**Consultation Response from: KC Environmental Health (Pollution & Noise Control)**
**2023/93539 Land adj Ledgard Bridge Mill, Back Station Road, Mirfield, WF14 8NZ**
**Outline application, including the considerations of access appearance, layout, and scale, for the erection of a six-storey building to host 76 residential apartments (C3 use) and ancillary works comprising demolition of vacant building, formation of new access, parking areas, open space and landscaping; erection of cycle and bin refuse storage structures**
**Date Responded:**  
**22 January 2024**
**Responding Officer:**  
**RM, MN**
**Responding Ref:**  
**WK/202340067**

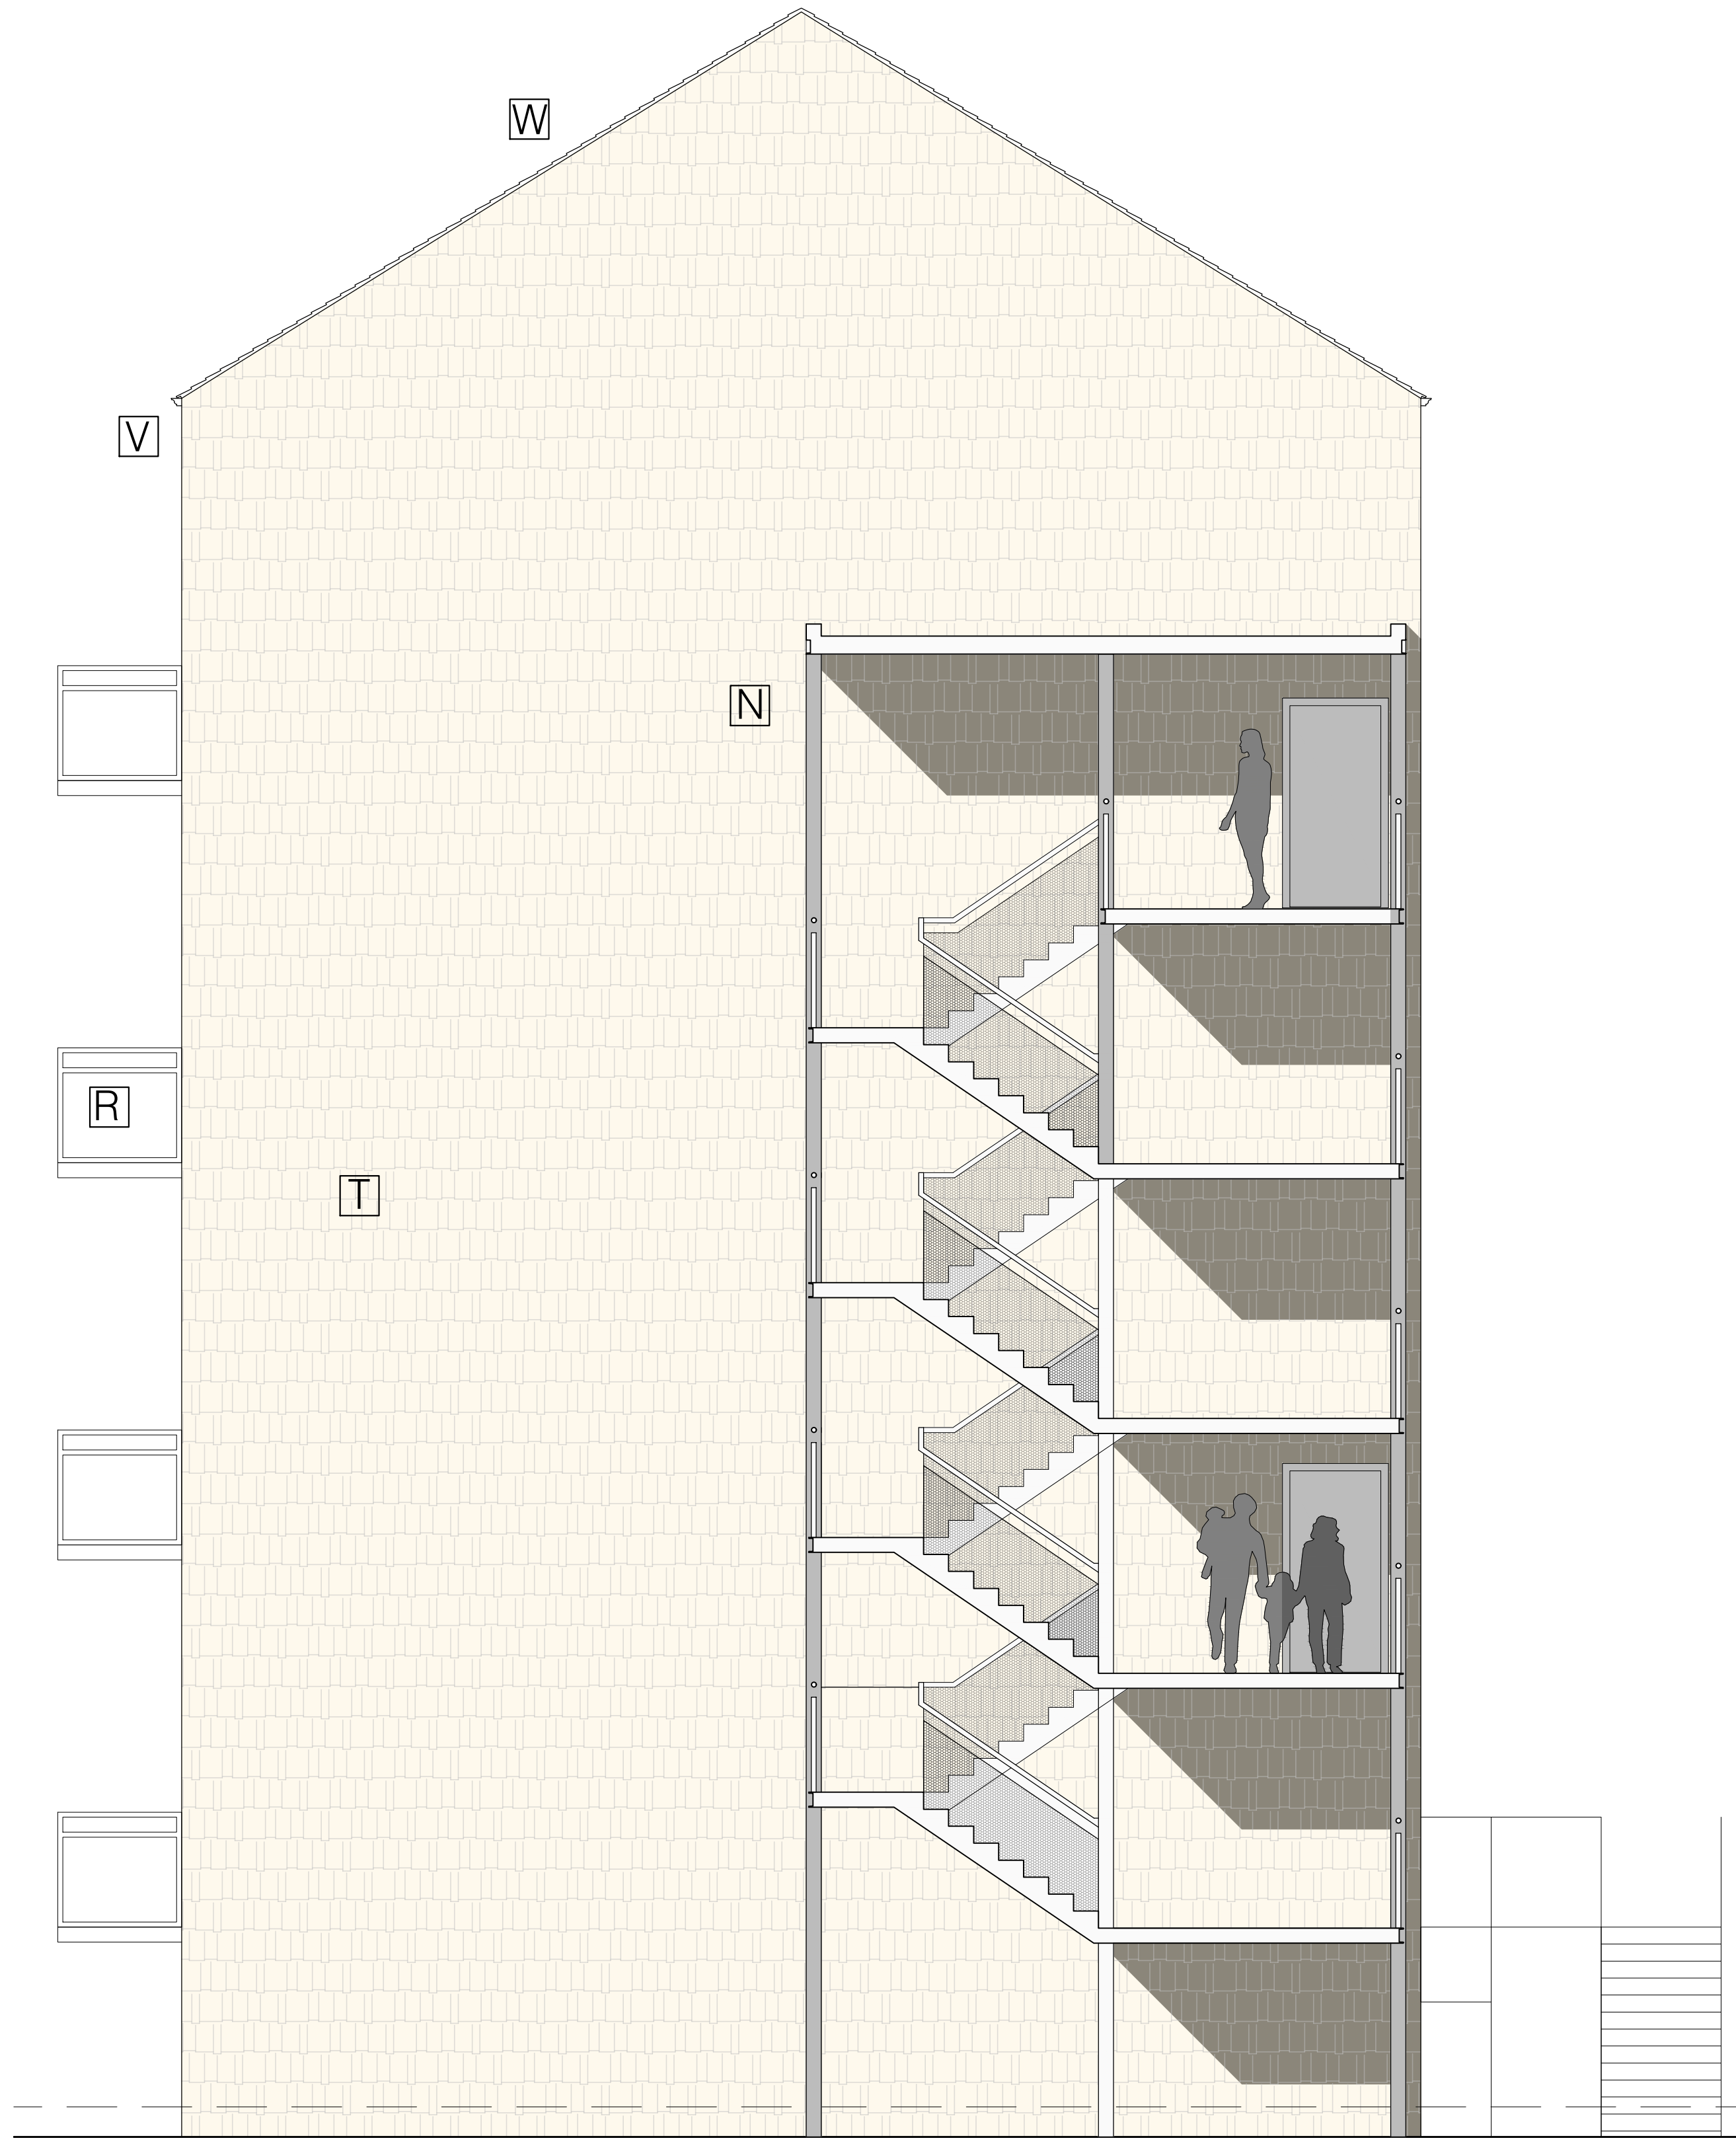
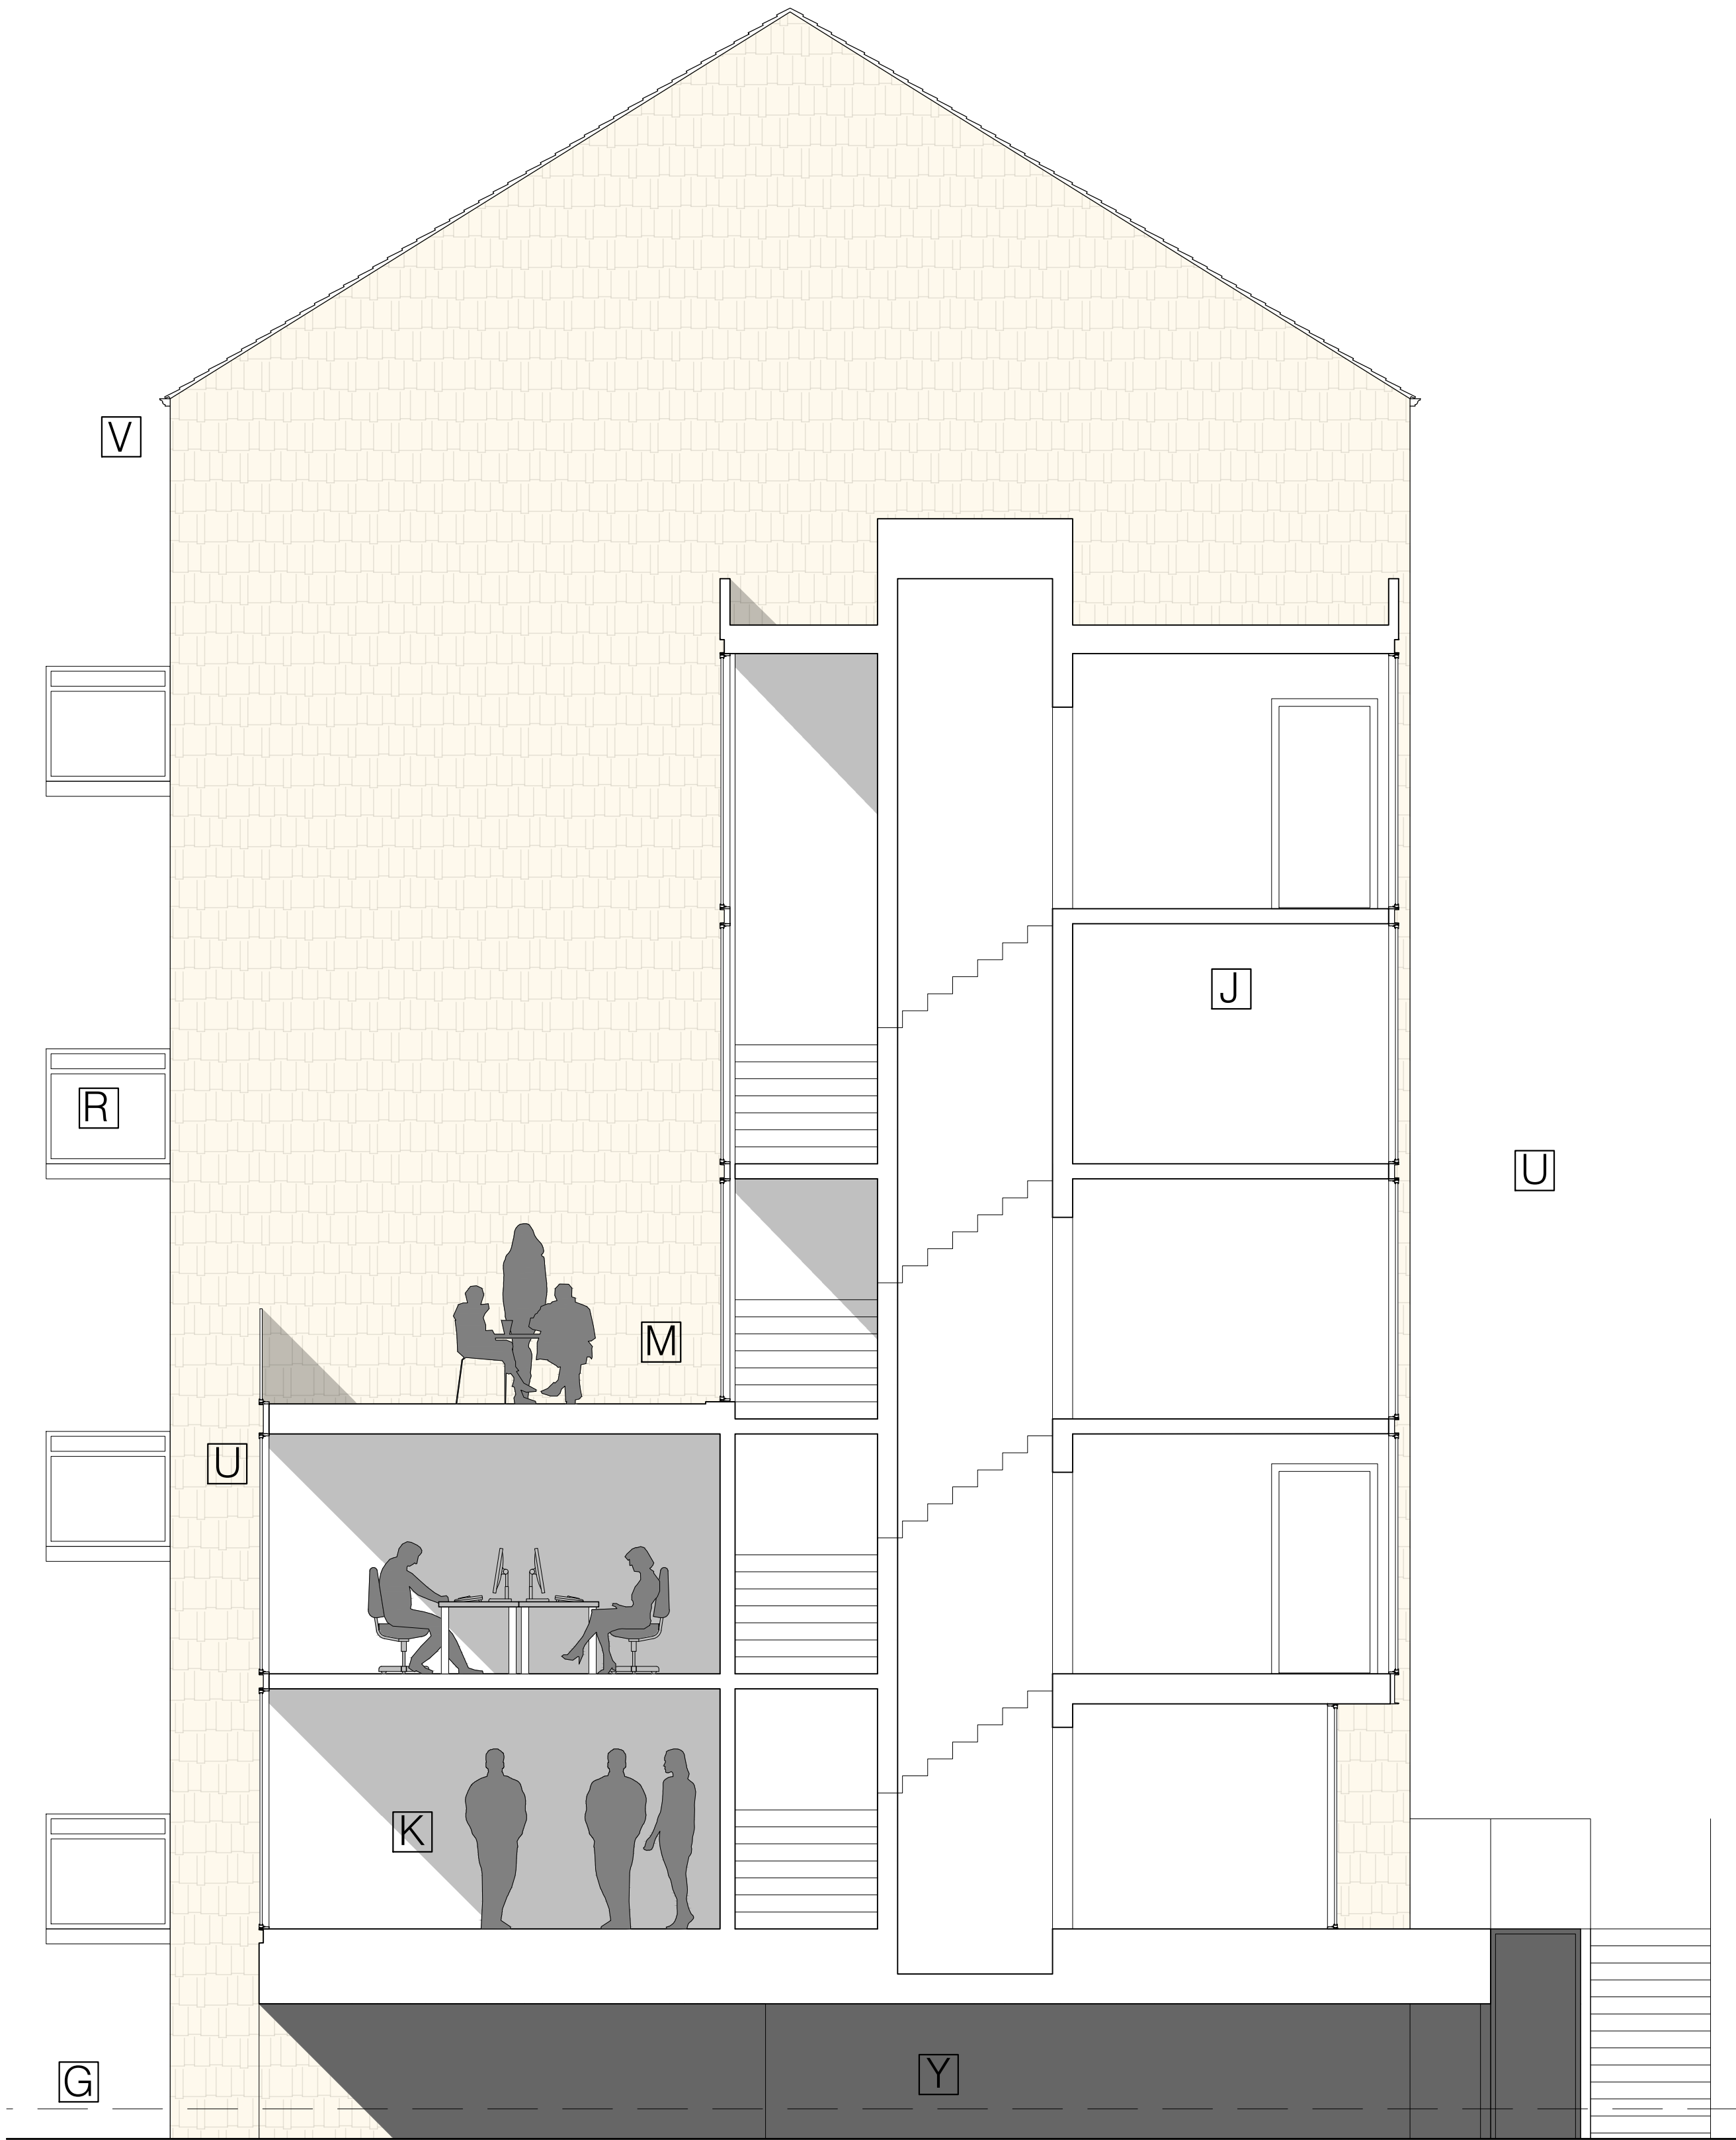
The submitted Planning Statement refers to a gym space split over two levels (ground floor & 1<sup>st</sup> floor) and plans from jg-d dated January 2022 show a residents gym marked as 'L' on drawing 17001\_3\_Floor Plans (Levels G-2) but this has not been covered by the submitted Noise Impact Assessment. The use is unlikely to be comparable to a commercial gym and so a condition is recommended for a Noise Management Plan to be submitted to consider the potential impact of this use on the amenity of the neighbouring occupiers. It should include, but is not limited to, management responsibility, hours of use, type of equipment, details of noise insulation and isolation materials etc.

#### **NC12 Noise Management Plan (Gym) - Condition**

Before the premises are brought into use, a Noise Management Plan shall be submitted to and approved in writing by the Local Planning Authority. The plan shall detail the control measures that will be taken to ensure that excessive noise does not arise from the use of the gym and the actions that will be taken to control any noise. The approved Noise Management Plan shall be implemented before use commences, reviewed periodically and retained thereafter.
